# CITY OF ALBUQUERQUE

August 17, 2022

**Re: Townhouse**  
**623 14<sup>th</sup> St. NW**  
**Traffic Circulation Layout**  
Architect's Stamp 07-11-22 (K13-D083)

Based upon the information provided in your submittal received 07-15-22, the above referenced plan cannot be approved for Building Permit until the following comments are addressed:

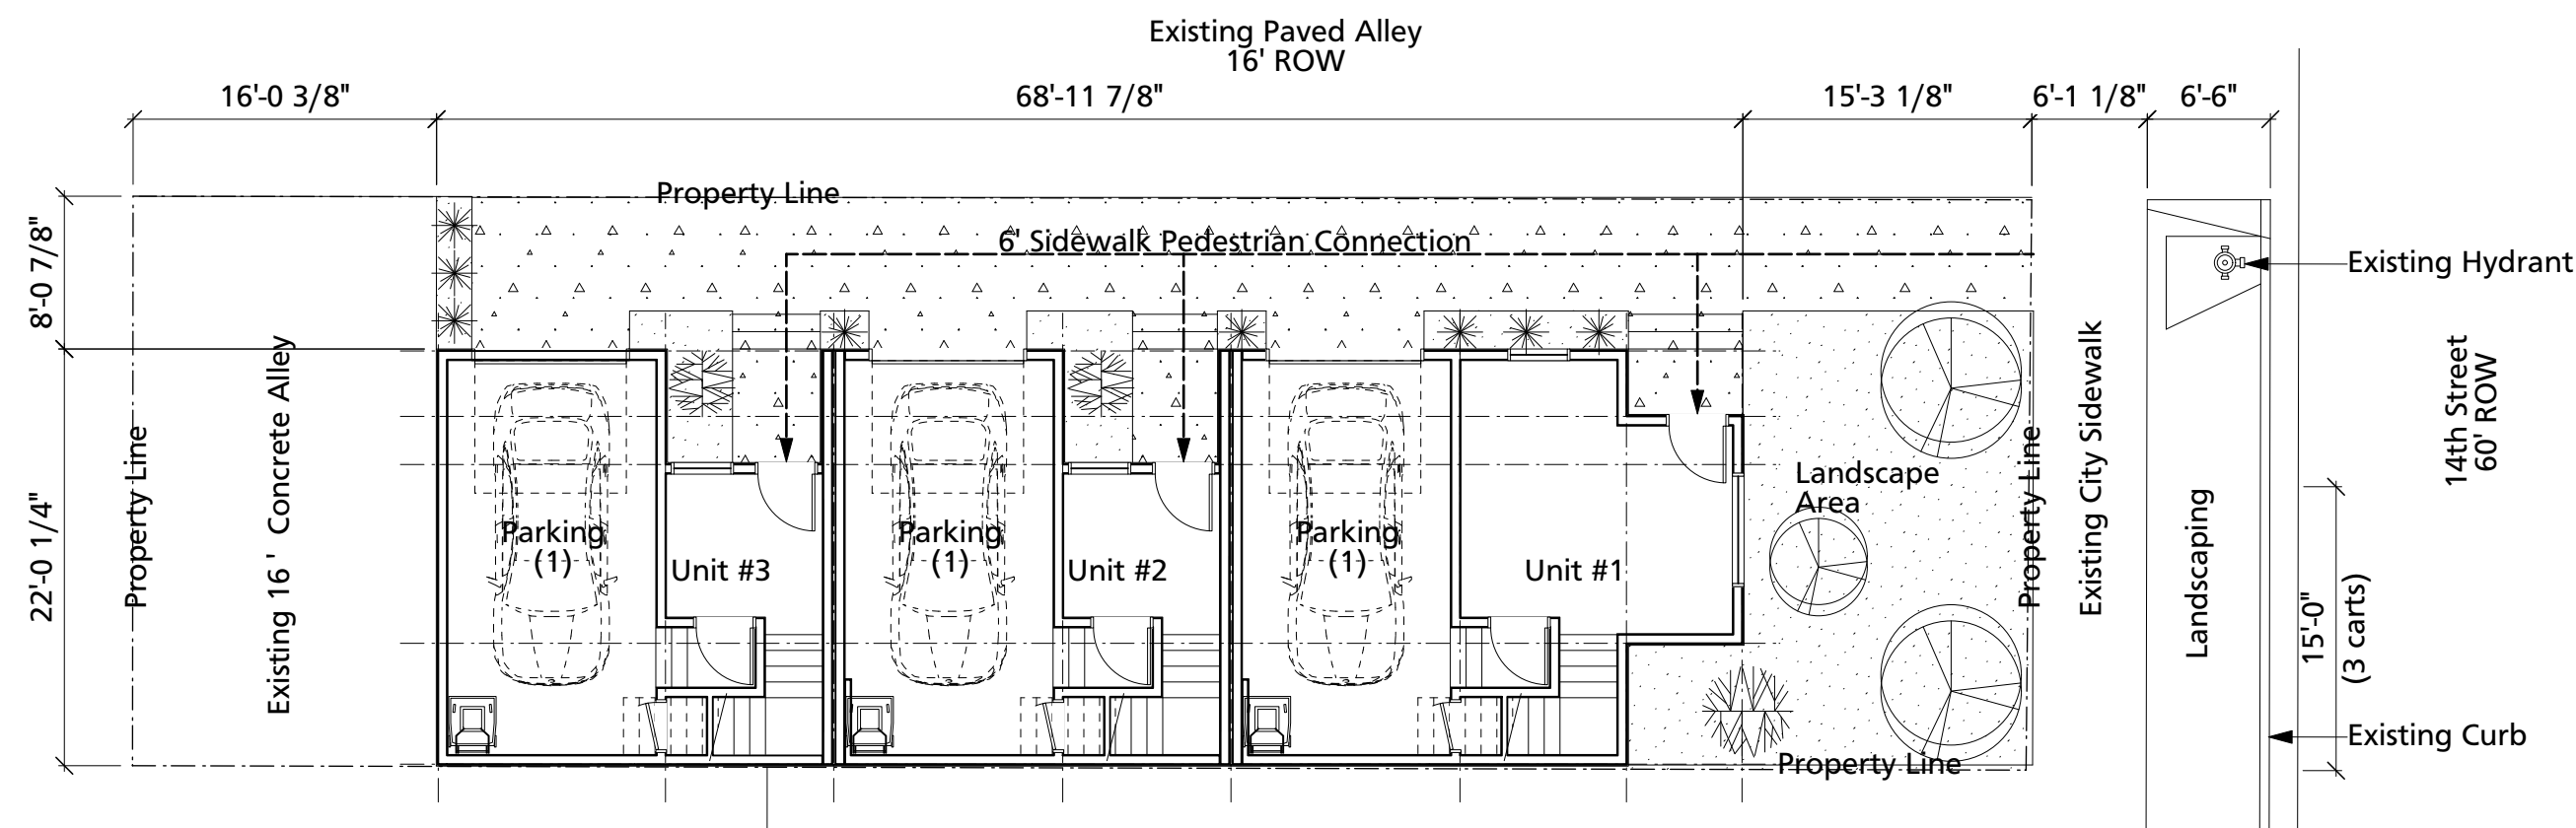
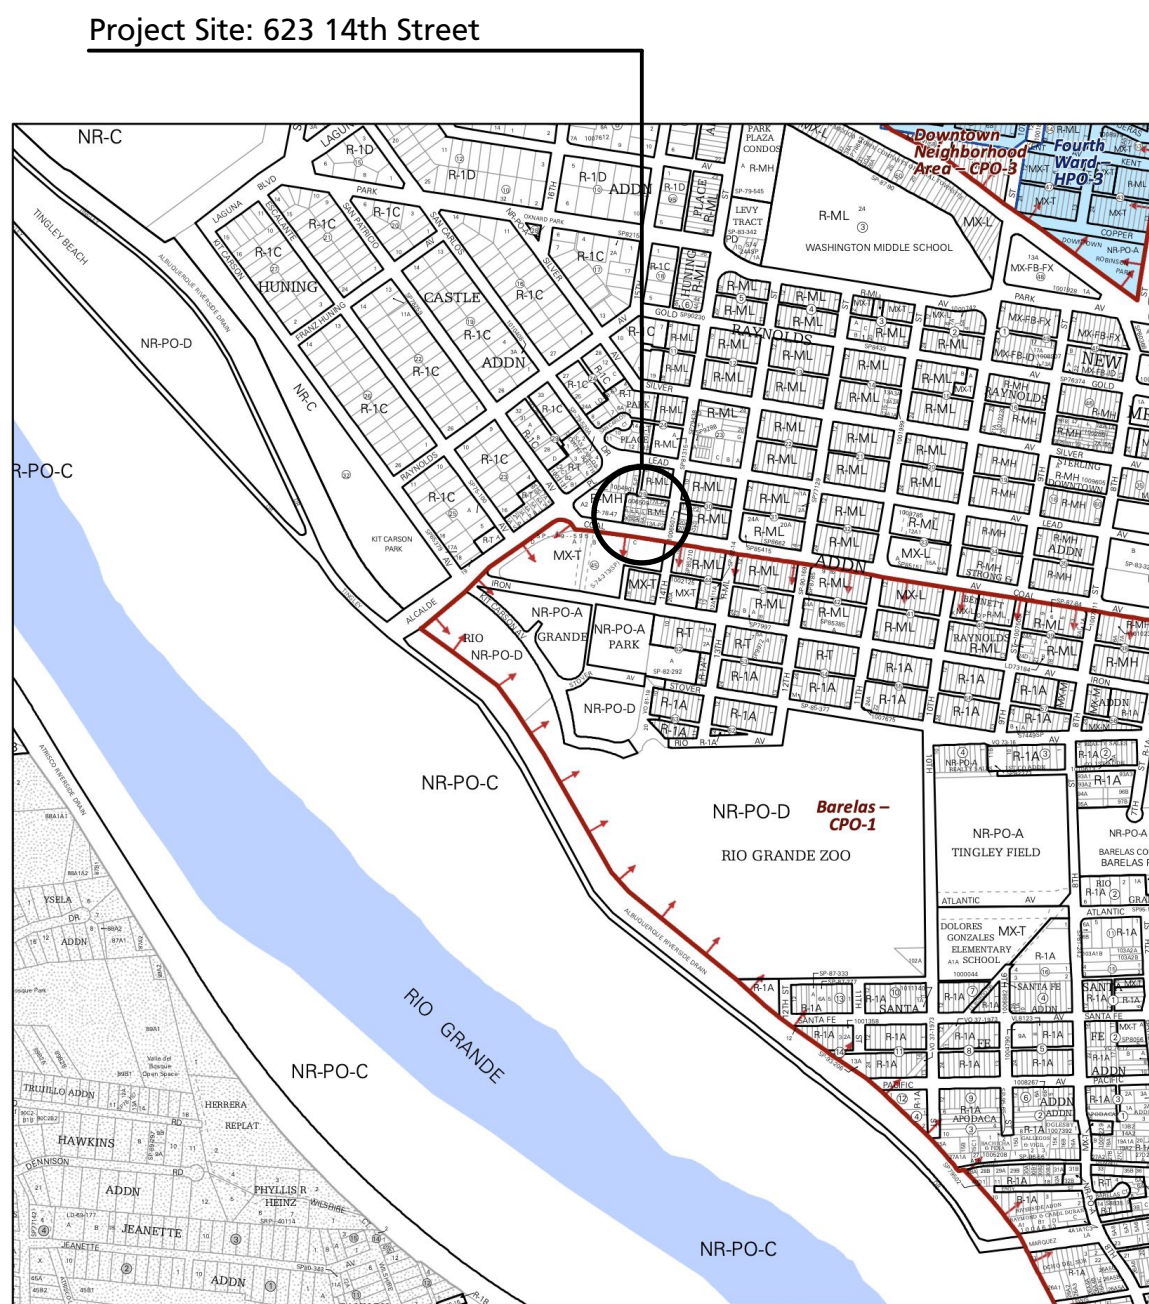
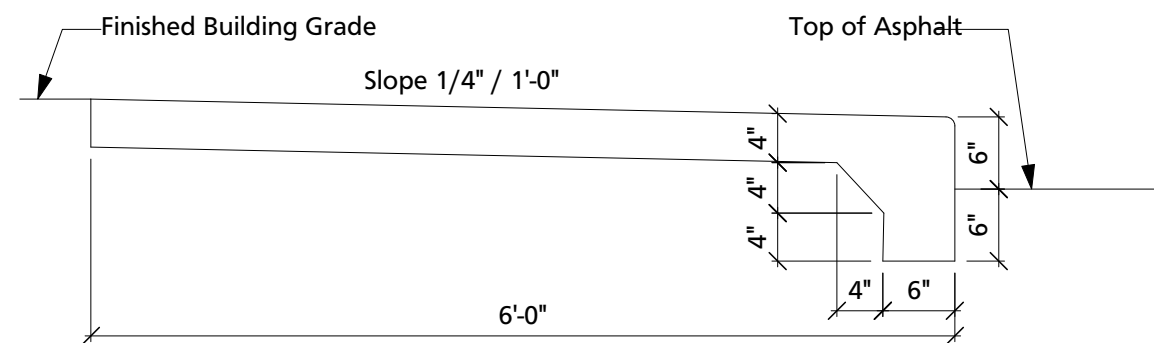
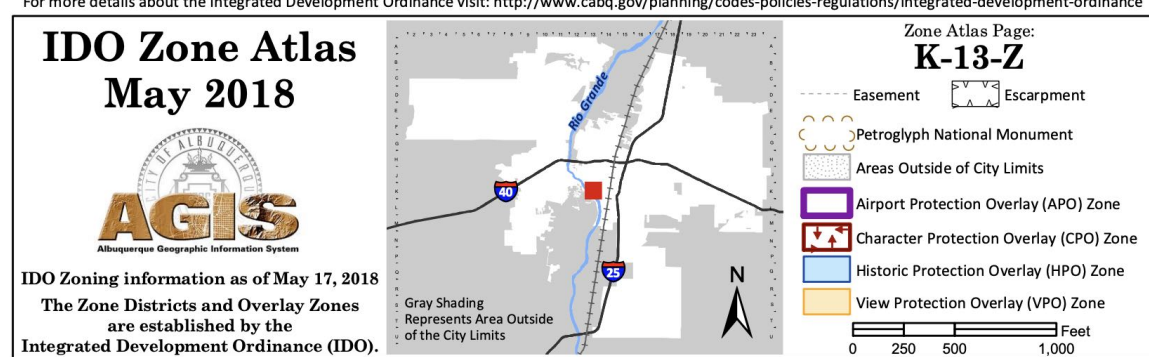
1. Provide the dimensions (width and length) for all the proposed parking spaces.
2. Provide shared access agreement with the property at the north side of your site.

3. Please define the pedestrian pathway from the public sidewalk to the building entrance, are there any ramps? If so, please provide all the proposed ramps details.

4. Please provide a sight distance exhibit
5. Show the clear sight triangle and add the following note to the plan: "Landscaping and signage will not interfere with clear sight requirements. Therefore, signs, walls, trees, and shrubbery between 3 and 8 feet tall (as measured from the gutter pan) will not be acceptable in the clear sight triangle. Please see attached Intersection sight triangle.

6. Please specify the City Standard Drawing Number when applicable.
7. Add a note stating "All broken or cracked sidewalk must be replaced with sidewalk and curb & gutter." A build note must be provided referring to the appropriate City Standard drawing.
